# Memorandum

**Re:** 120 Preble St.

I have commenced the review of the plans and have the following questions:

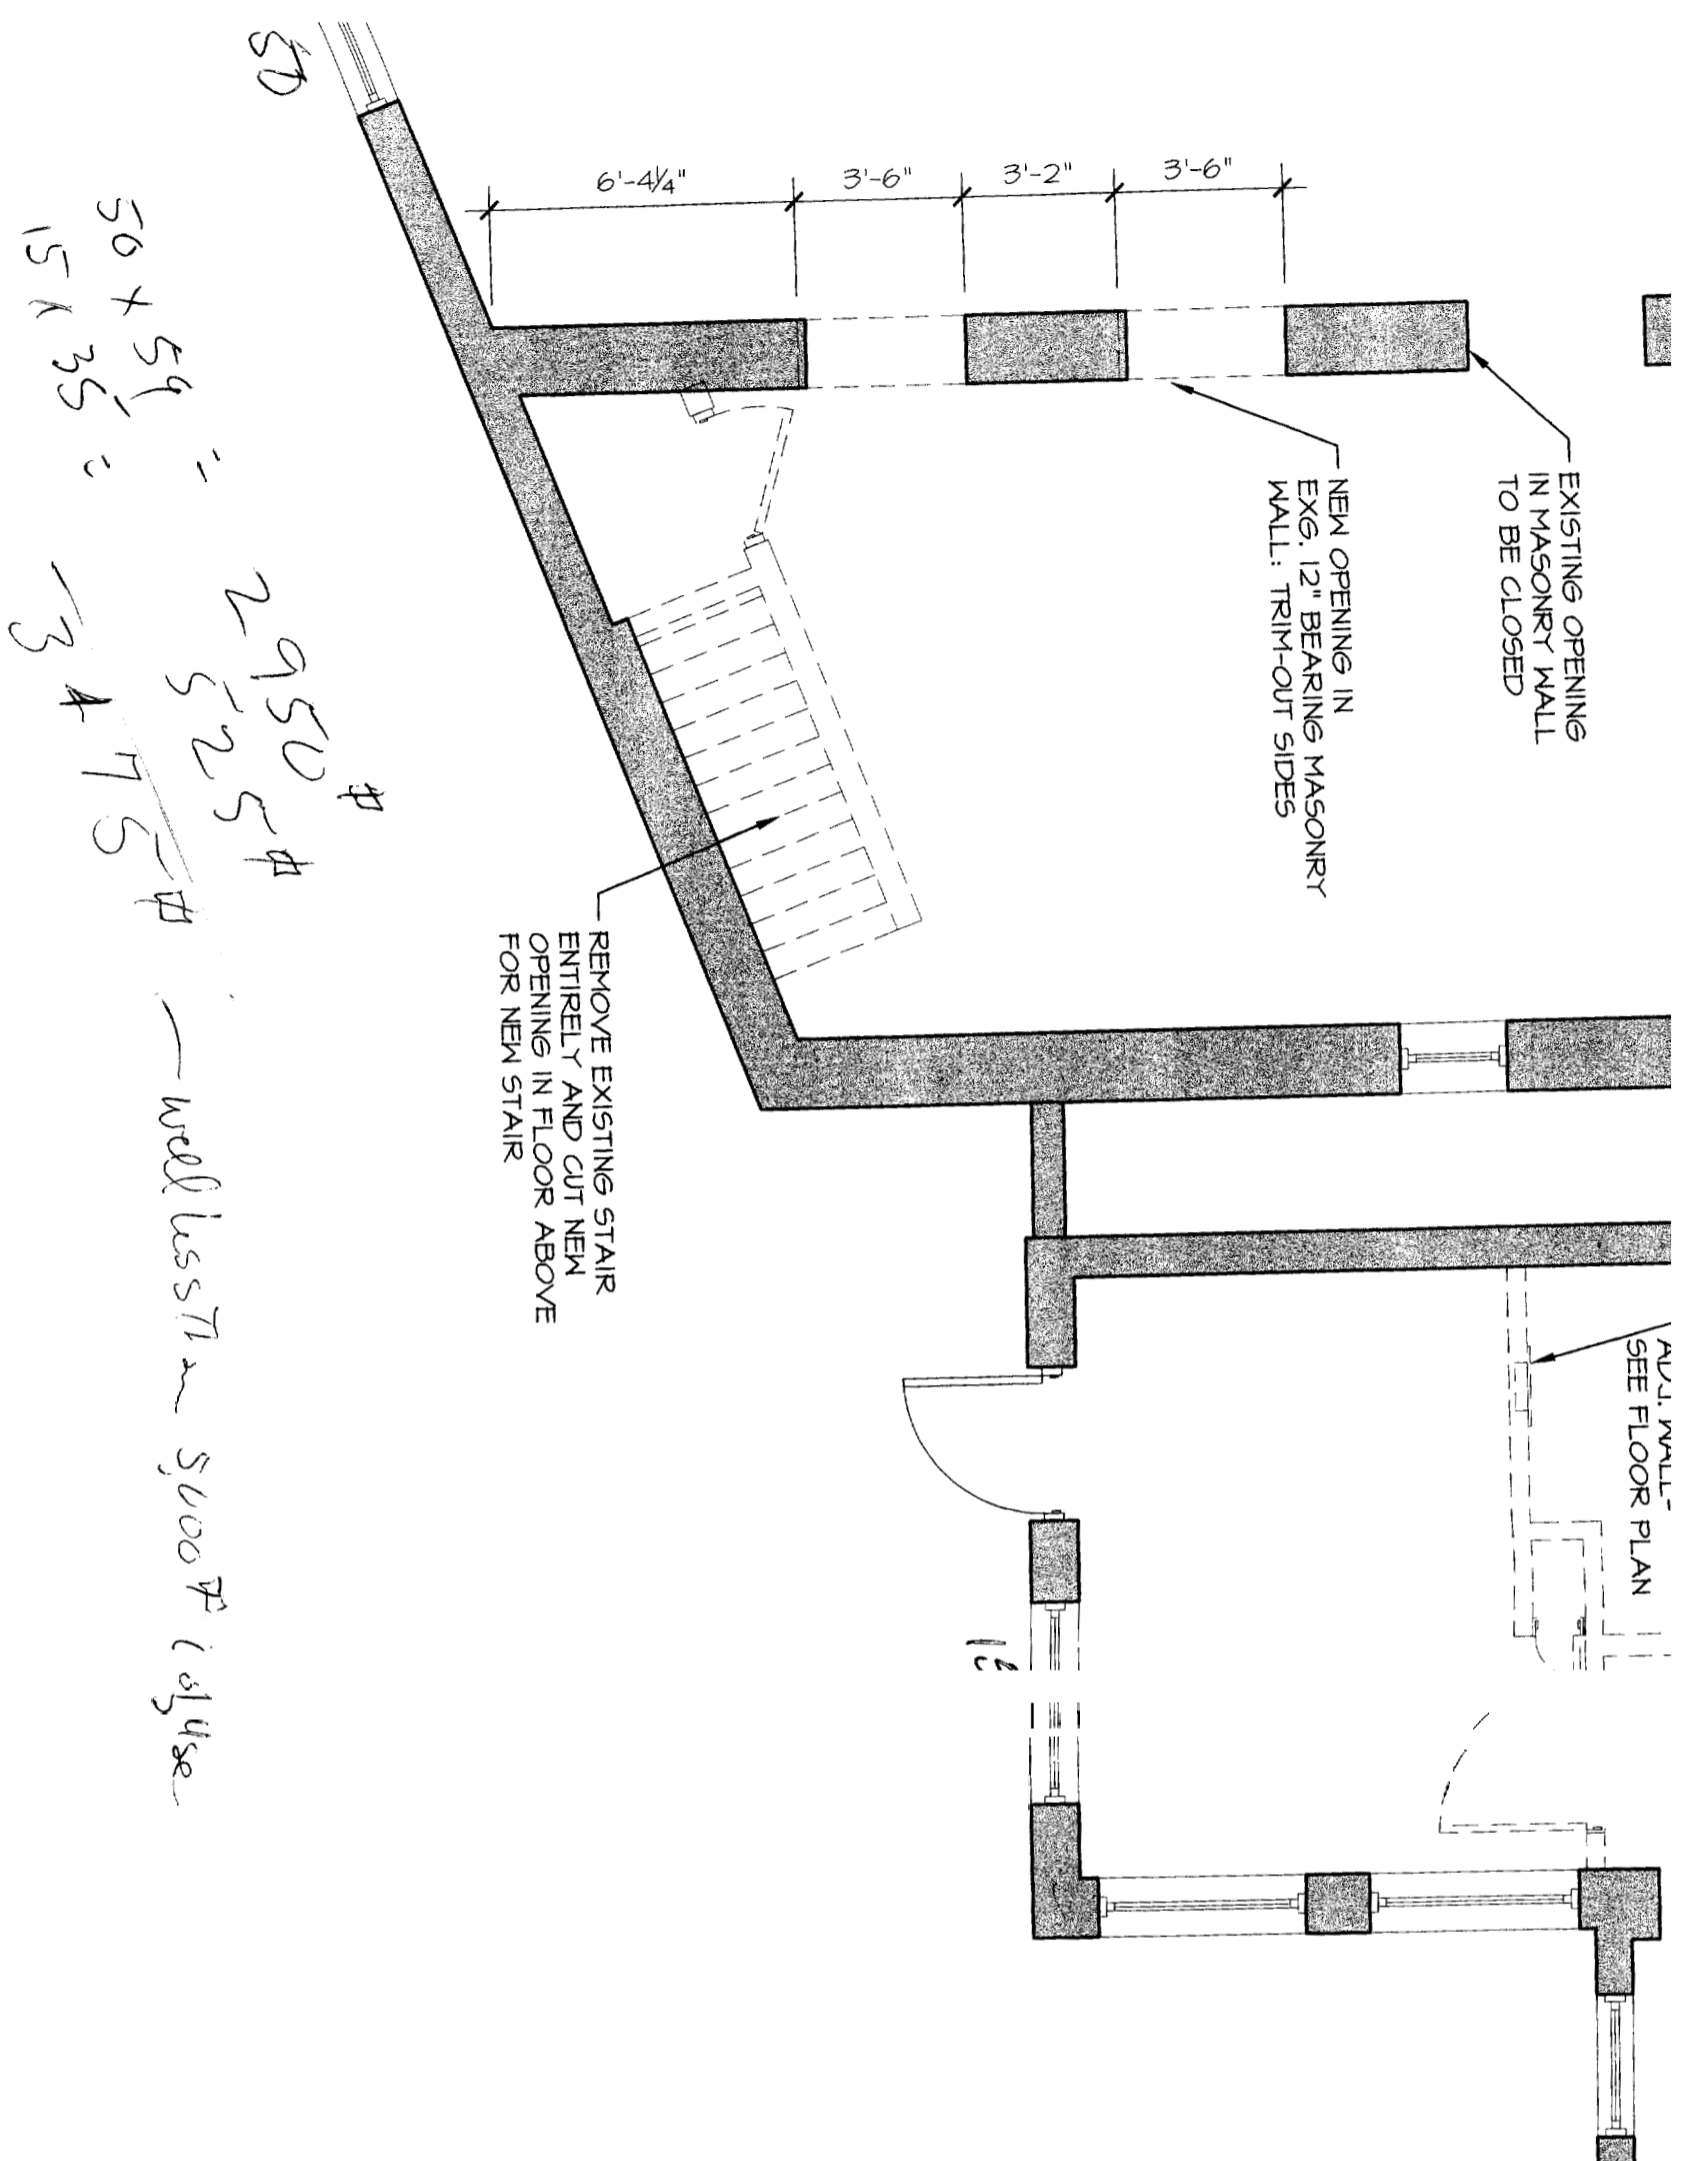
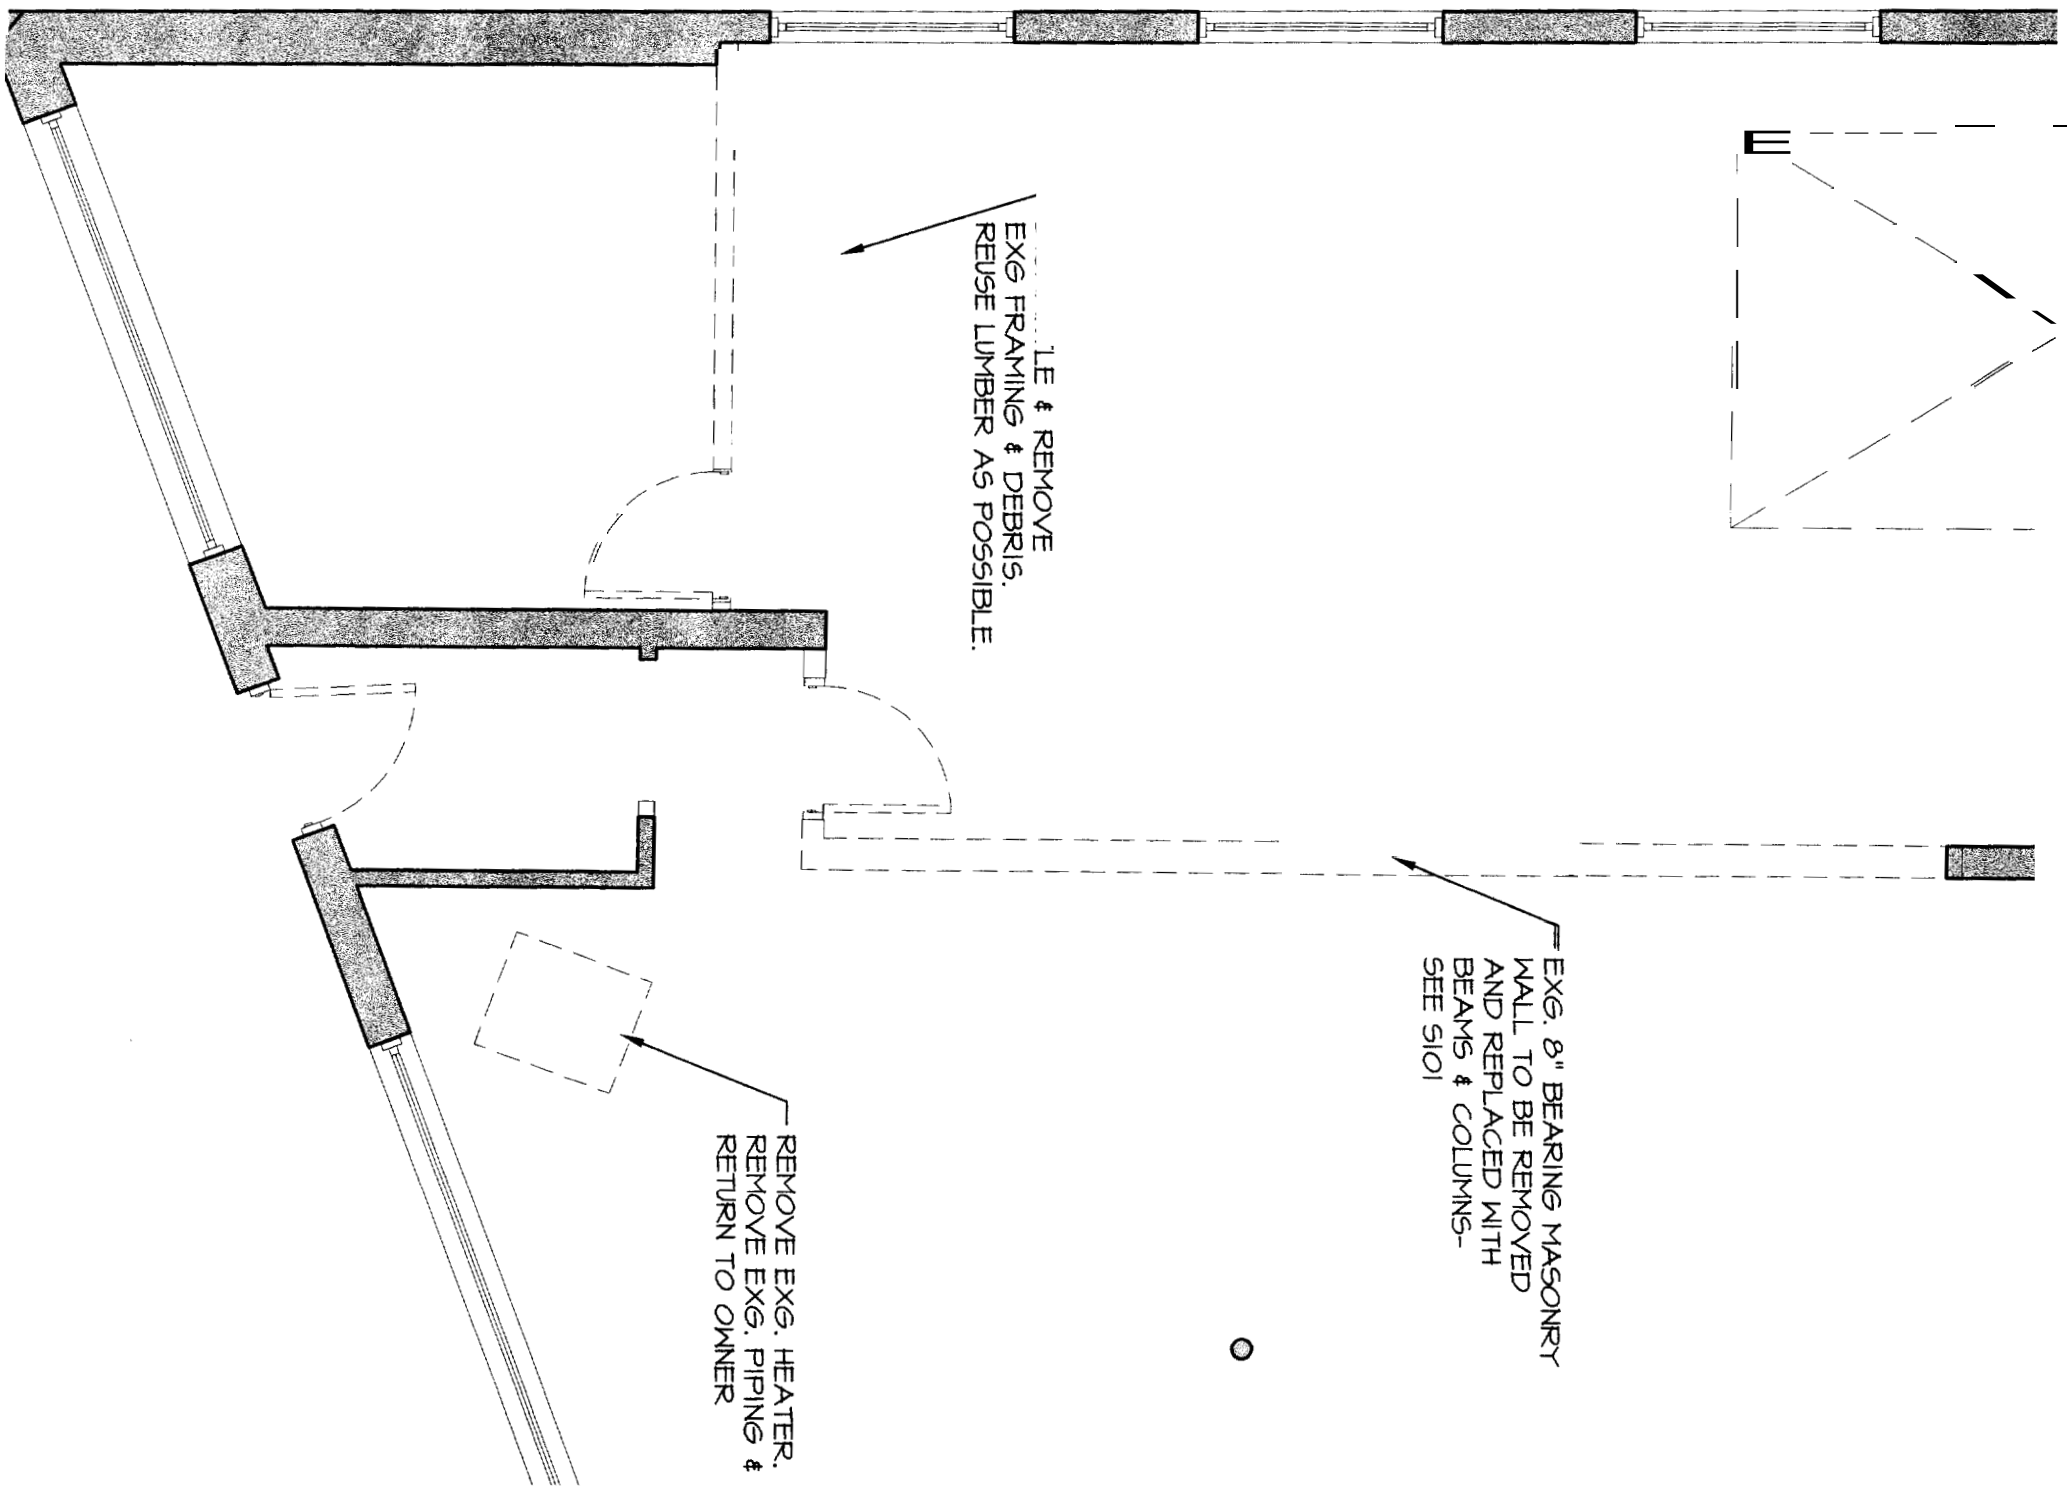
- 1) Please provide HVAC, Plumbing and Electrical Plans, including a local exhaust system design, that comply with the 2003 IMC, 1999 NEC and the Maine State Plumbing Code.
  - 2) Please provide Stair details that include tread, riser, headroom and width dimensions.
  - 3) Please document the load capability of the floor system above the basement areas.
  - 4) Please review Chapter 8 of the IBC and provide applicable information with regard to interior finishes.
- 
-
